**CHARLOTTE - MECKLENBURG**  
**PLANNING COMMISSION**

**SUBJECT:** Administrative Approval for Petition No. 2006-22 by Live Oak Development Partnership, LLC.

BY: DEBRA D. CAMPBELL  
Live Oaks Property  
Rezoning

SHEET NUMBER  
RZ-1

PROJECT NO.
101.1686.00
ISSUE DATE: 4/03/06
SHEET NUMBER: **RZ-1**

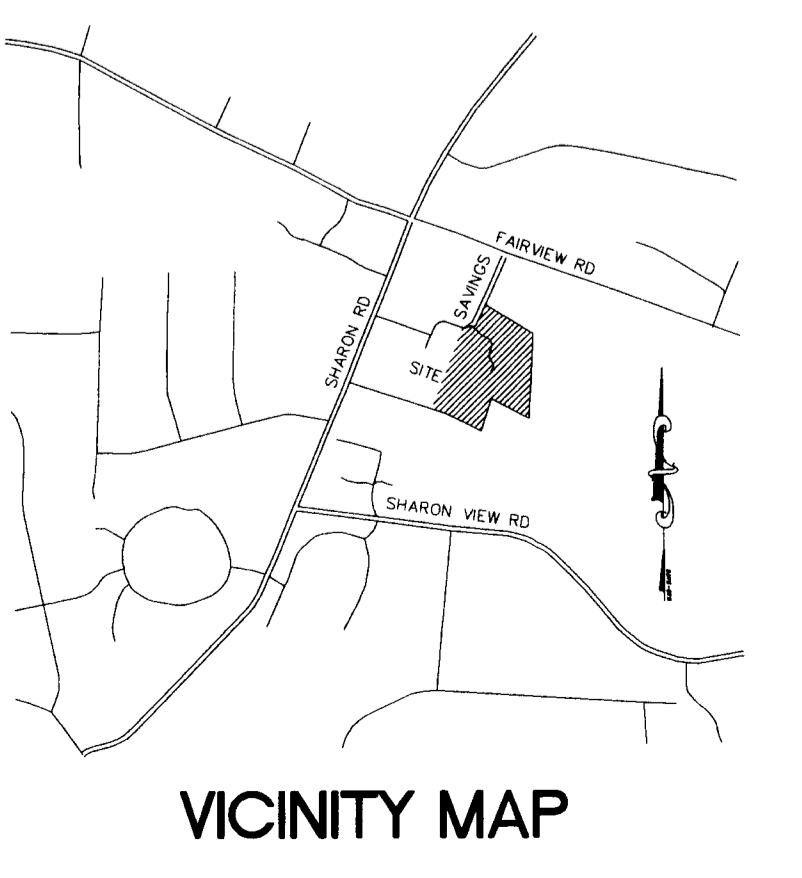
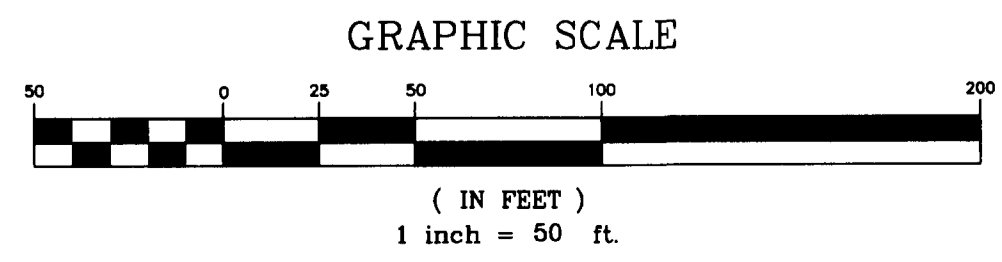
Attached are revised plans for the above petition. The plans have been revised to allow balconies, within buildings constructed within area "B", on the first and second level facing south toward boundary "A". Since this change is minor, I am administratively approving these revised plans. Please use these plans when evaluating requests for building permits and certificates of occupancy.

- i. Structured Parking within Development Area B adjacent to property boundaries A, B, and C will not exceed 14 feet in height as measured from the average elevation along the perimeter of the structure to the elevation of the parking surface of the Parking Structure. Opaque walls or other architectural treatments for screening parking from adjacent properties may occur within the Development. Balconies within development Area "C" will only be allowed to face east and west, within the Site, and will not be allowed to directly face property boundaries "A" and "C". Balconies within Development Area "B" may occur on all building sides, however those balconies facing property boundary "A" may only occur on the first and second levels.
